From: Michael Eastham
Sent: 17 November 2017 15:36
To: Planning.Responses
Subject: FW: BE/102/17/OUT

Further to the comments/queries raised by the EHO, please see comments in red below and attached.

1. The report only deals with noise in detail for Unit 2 and whilst I understand this because the application is for full permission for Unit 2 and outline for the rest of this site, I have concerns that there may be cumulative noise impacts as unit 1, 3, 6 and 7 also either be B1/B8 use and they may have associated HGV movements. I am concerned that any cumulative noise impacts have not been taken into account at this stage and wants out my permission has been given may not be fully resolvable at that point. But the applicant confirm whether they have taken this into account or not?

1 BLOCK PLAN - SHADOWS
1:1000

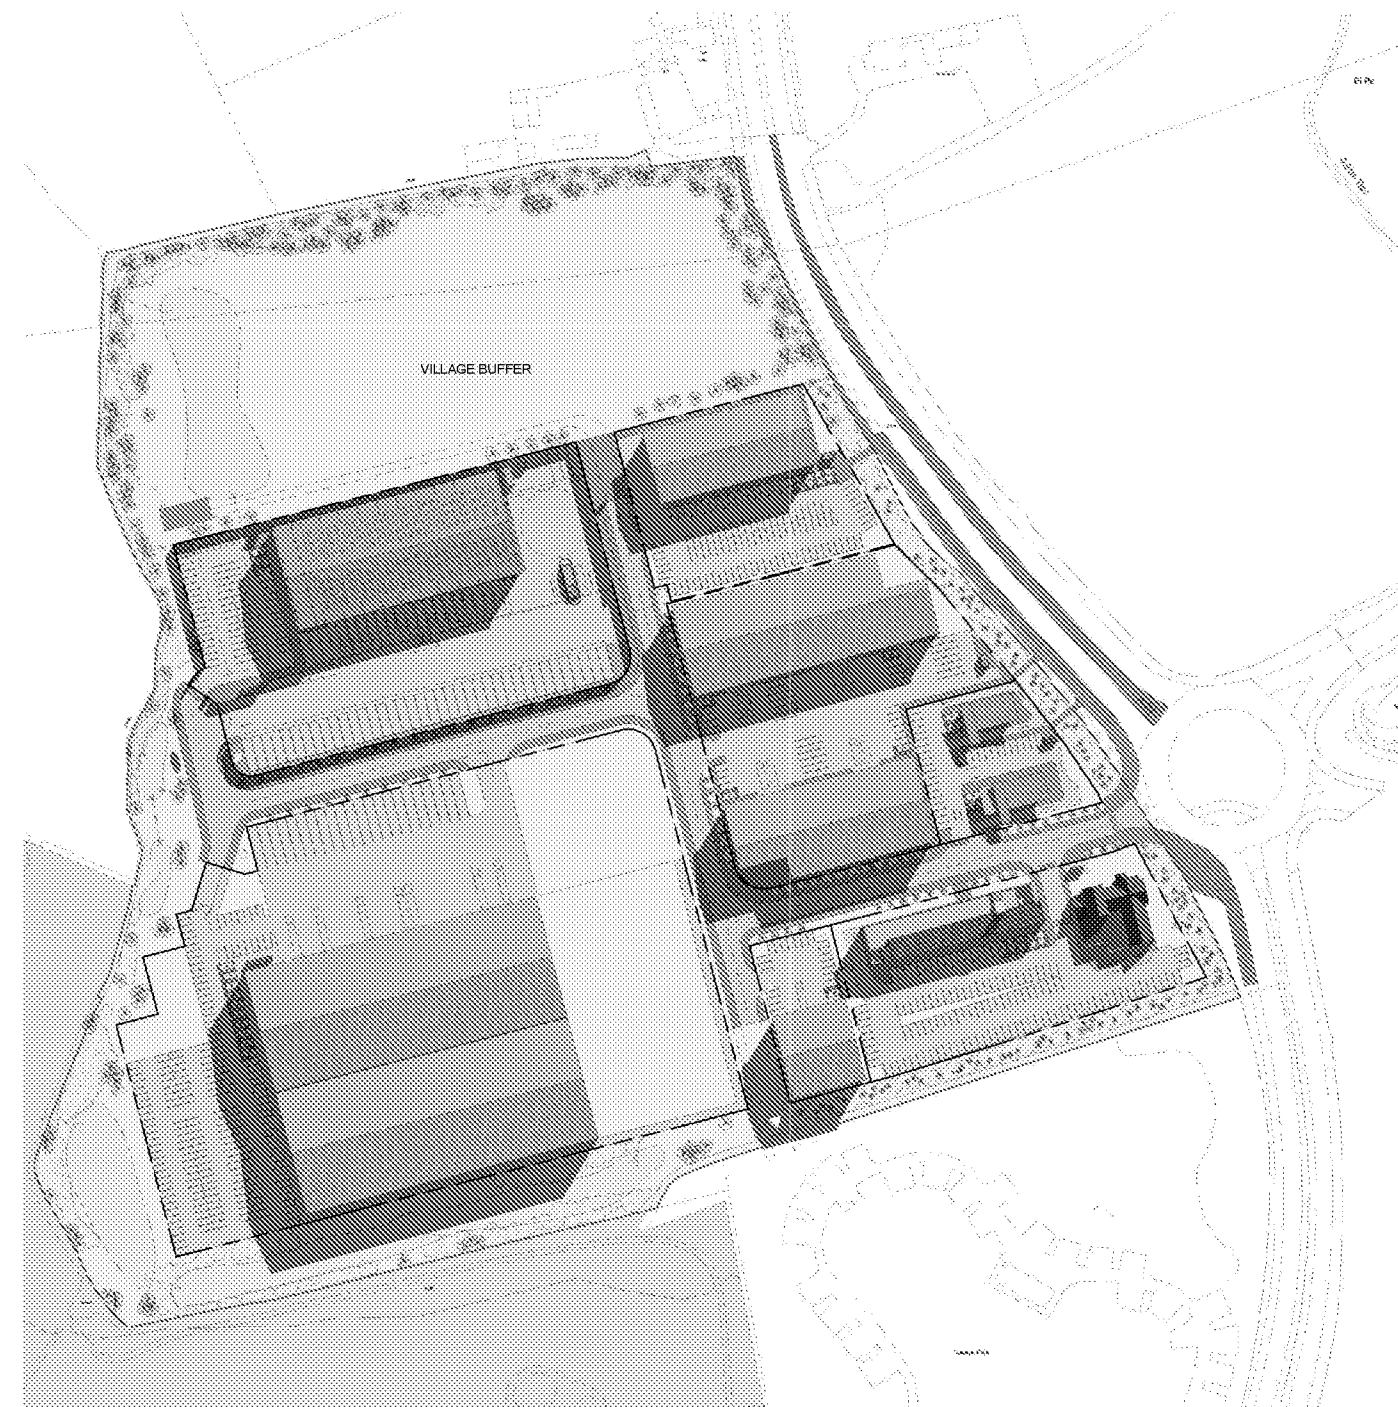
6. Paragraph 4.21. This states that a level dock loading bays will be sited at the northern elevation. Does this mean loading to and from HGVs will take place facing north i.e facing the Shripney Road properties? If so paragraph 4.23 cannot be consistent with paragraph 4.21. If the loading bay is at the north by definition the doors will have to be opened and closed frequently for accurate access and egress of product so acoustic performance of the warehouse structure cannot rely on the doors being closed. However looking at the plans it appears that the loading docks will be on the southern elevation. Please could the applicant clarify?

Apologies for the typo. As per the plans, all loading bays are to the south of the site. There is no loading /unloading to the north. Para 4.21 should read ..”sited at the southern boundary”

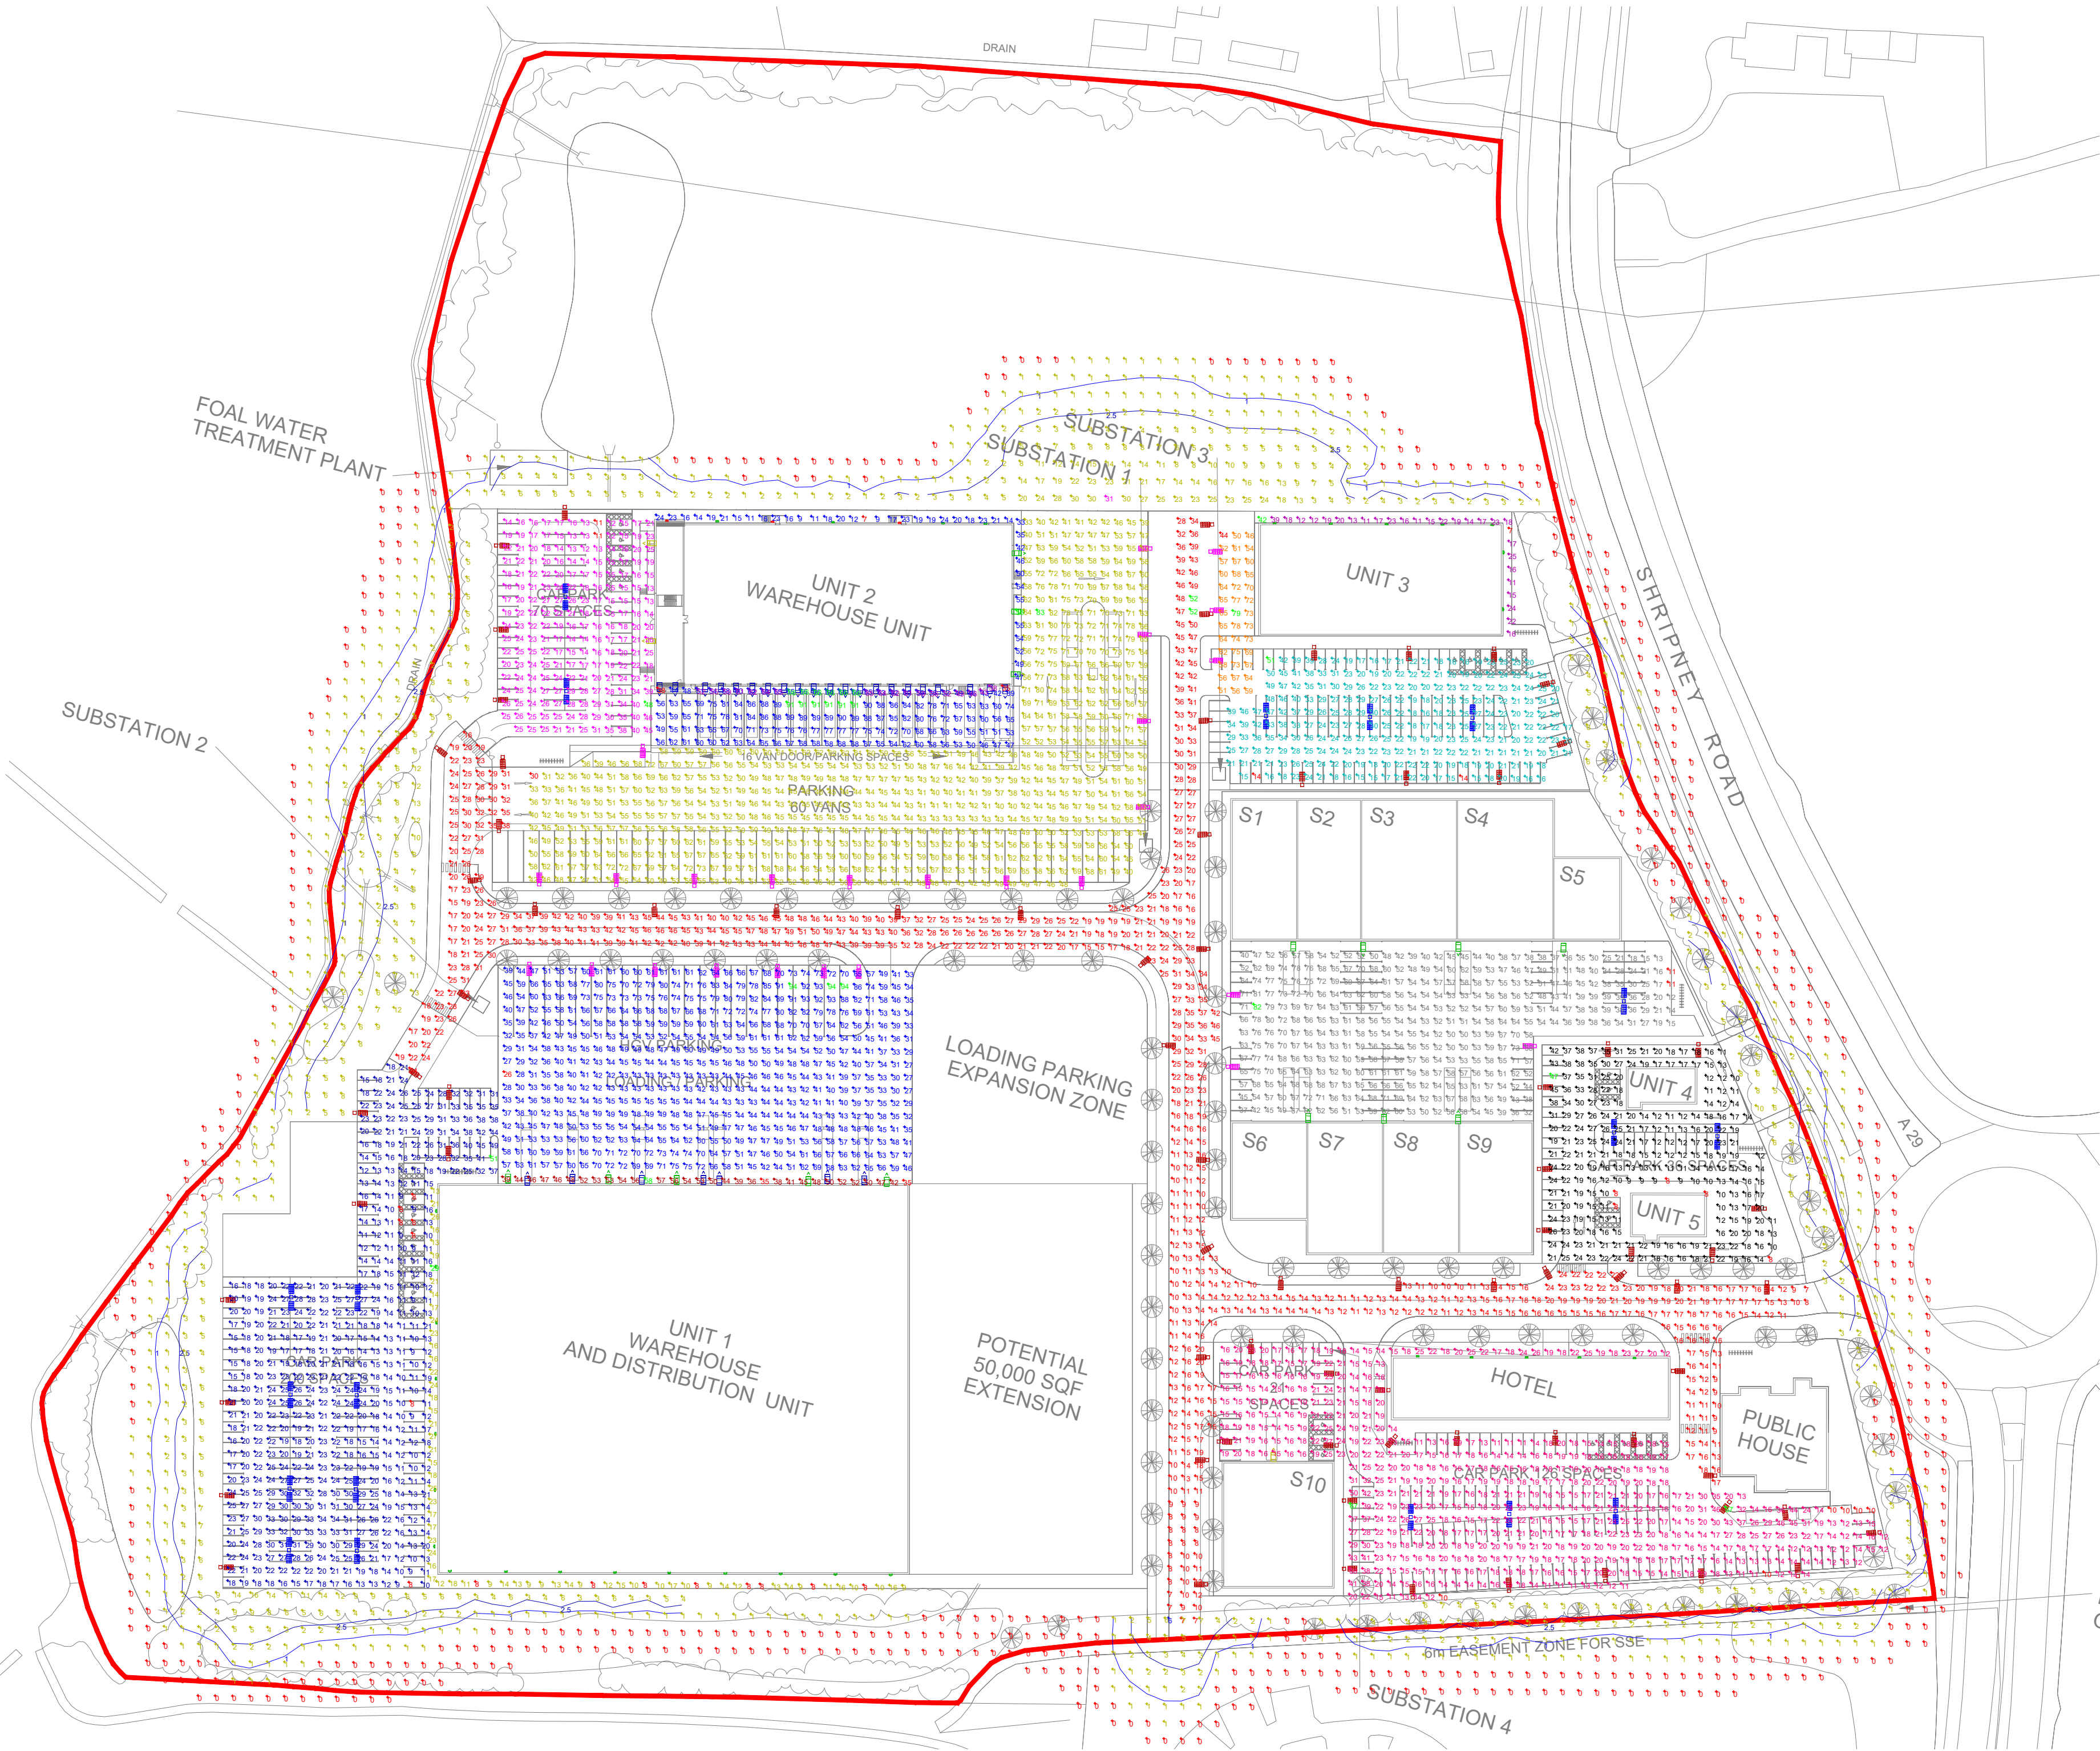
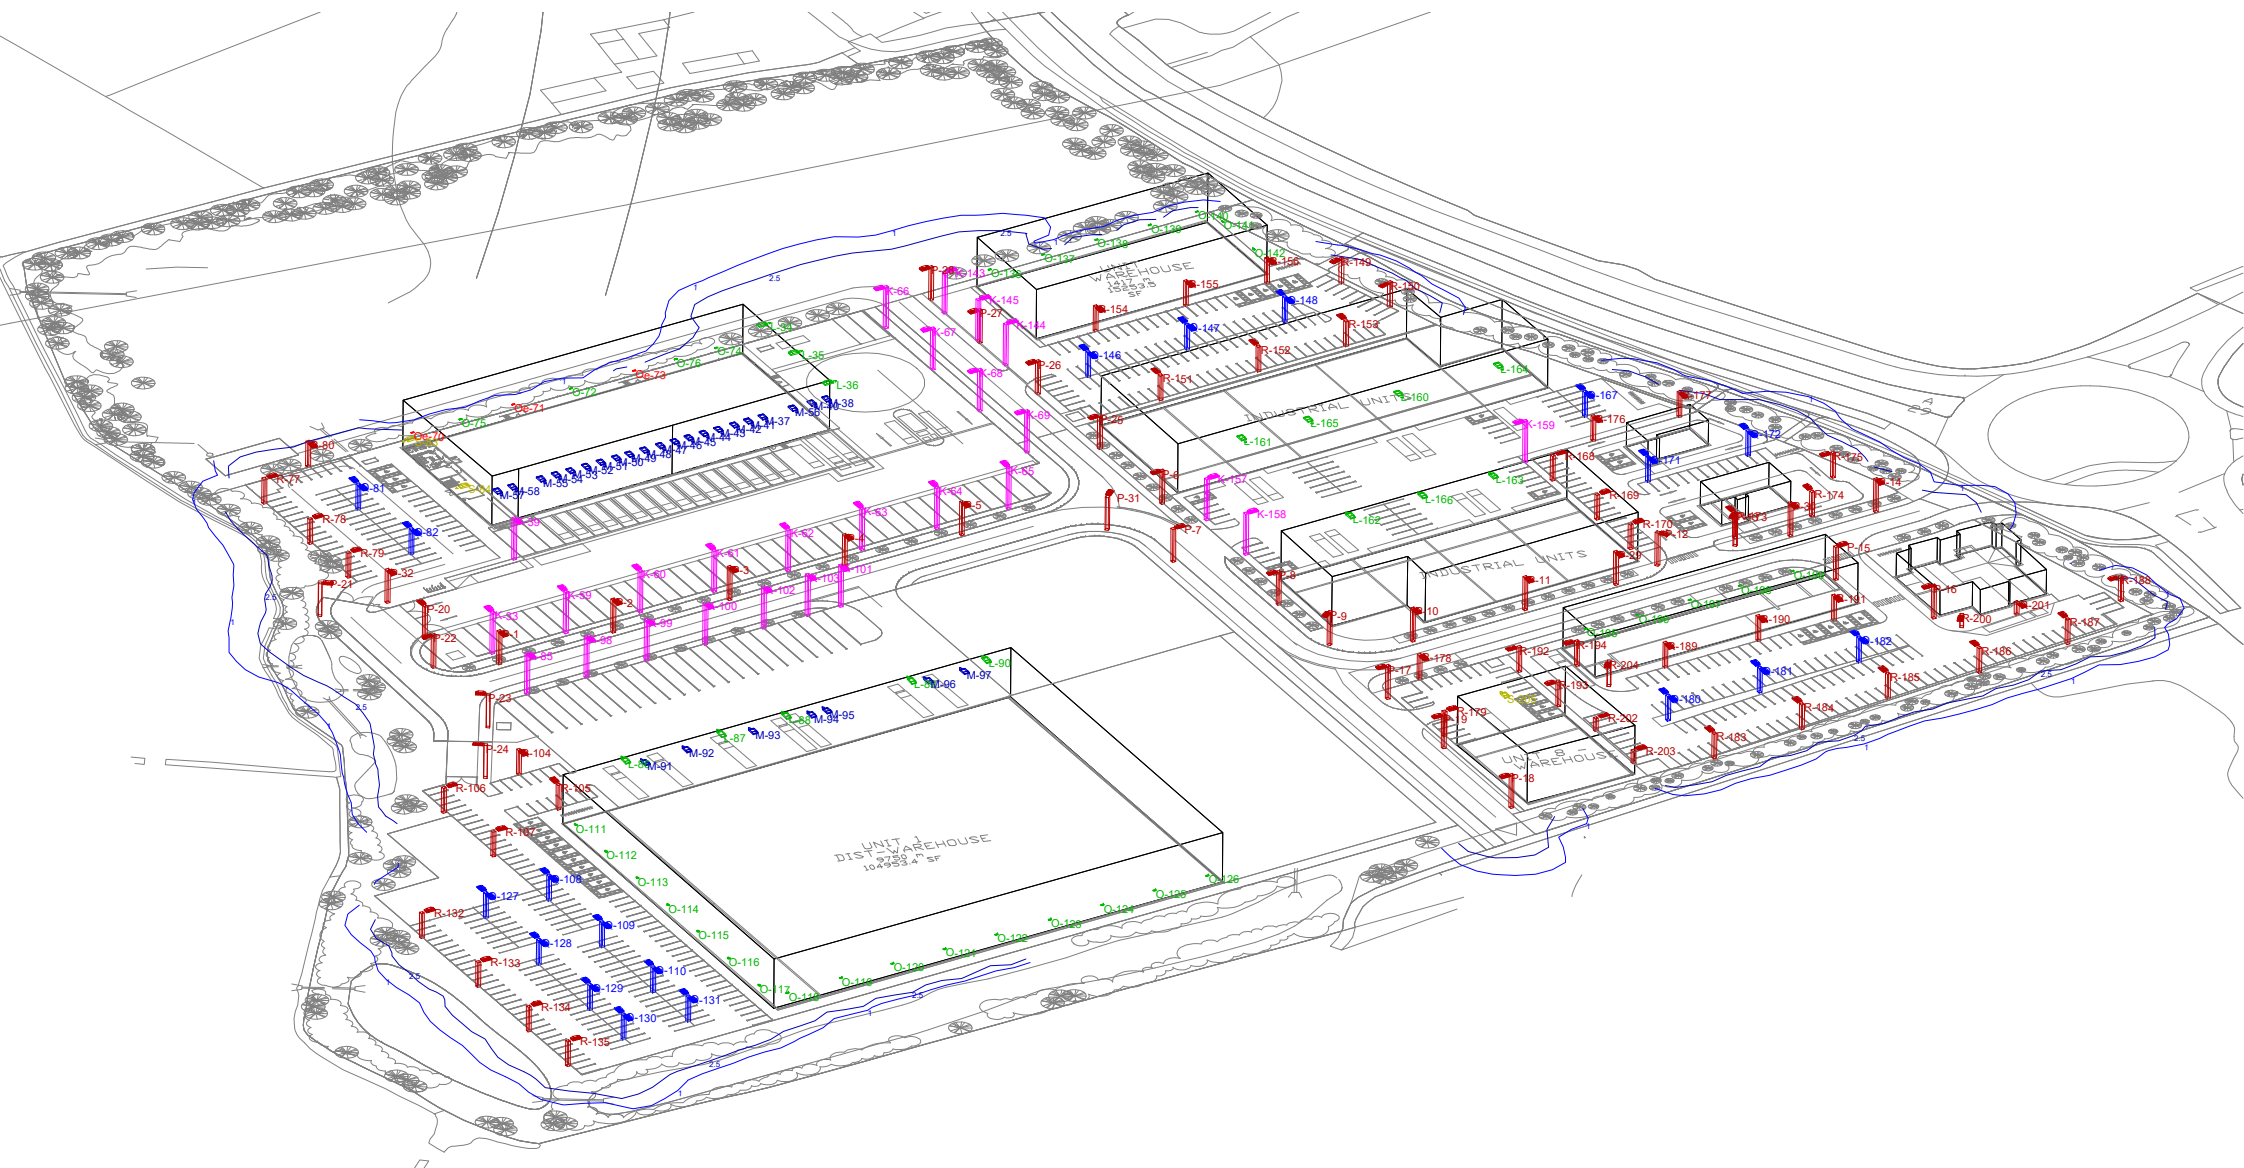
In terms of **Question 8** in Fiona's email regarding lighting (E2 or E3), the Local Planning Authority considers that, when the application site is viewed from the north, east and west it constitutes "rural, small villages or relatively dark urban area" and E2 lighting should be used rather than E3.

8. With regards to lighting please could the applicant give a justification for using zone E3 rather than zone E2?

9. Also with regard to lighting would the applicant consider using reduced coverage between 11 PM and 7 AM in line with the world health organisation guidelines? Although the WHO guidelines relate to noise it is considered that 11 PM to 7 AM is the night time, hence my question.

I have checked with the proposed lighting manufacturer and can confirm the proposed scheme produced is E2 compliant.

If the preference is E2 this can be amended. Although I believe we are closer to a small town than a small village.

Please refer to item 1.6 within the external lighting statement. Lighting will be photocell/timedclock controlled. Times can be added/adjusted to suit.
